**PROPOSED INIS CEALTRA VISITOR
CENTRE TOURISM EXPERIENCE
PROJECT VILLAGE CAR PARK
ENTRANCE JUNCTION ON MAIN
STREET AND VISITOR CENTRE
ENTRANCE JUNCTION ON HARBOUR
ROAD, MOUNTSHANNON, COUNTY
CLARE**

Stage 1 Road Safety Audit

Clare County Council

October 2024

TITLE: SITE LEVELS AND ROAD LAYOUT (SHEET 2 OF 2)

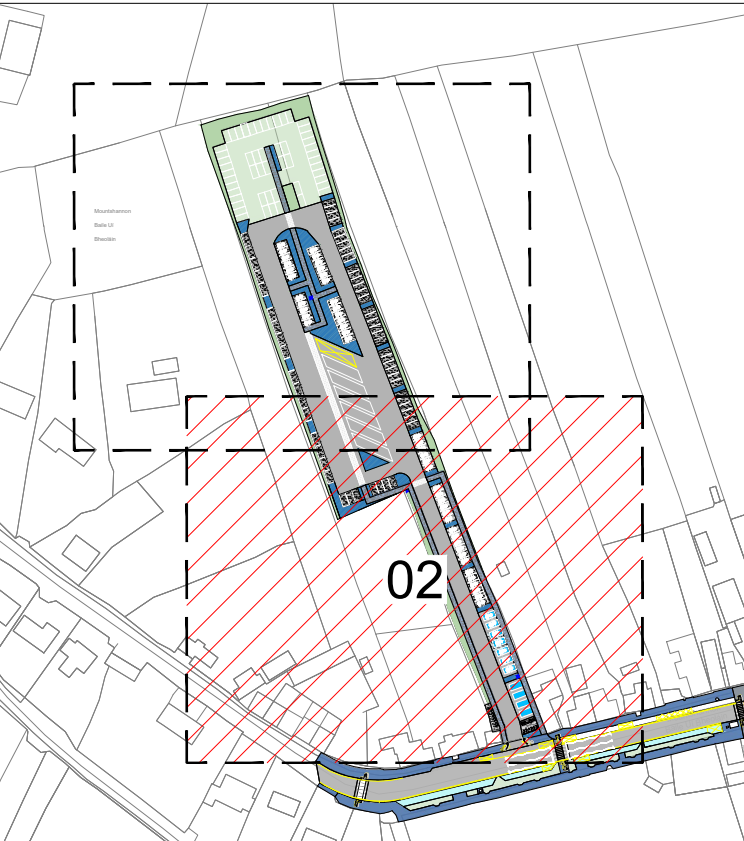
2.1 Problem – No Details of Footway Treatments at Junction Crossing Location

The existing footway along the north side of Main Street is continuous, with priority for pedestrians, along the existing site boundary for the proposed Village Car Park. It is proposed to discontinue the Main Street north side footway on either side of the proposed Village Car Park entrance road junction, with no priority measures (raised at-grade crossing surface) for pedestrians. There are no details of footway treatments for pedestrians at the junction, including for mobility and visually impaired users. Lack of appropriate treatments for vulnerable users could put them at increased risk of trips, falls, conflicts, vehicle impacts and injuries.

It is recommended that appropriate facilities should be provided for pedestrians, with reference to DMURS and the DoT Traffic Management Guidelines.

2.1	Yes	Yes	Tactile paving and drop kerbs will be indicated on the proposed design to facilitate pedestrians. pppropriate	
2.2	Yes	No	Outside scope of this design package. Clare County Council will be notified to advise their public realm designers of this.	Yes
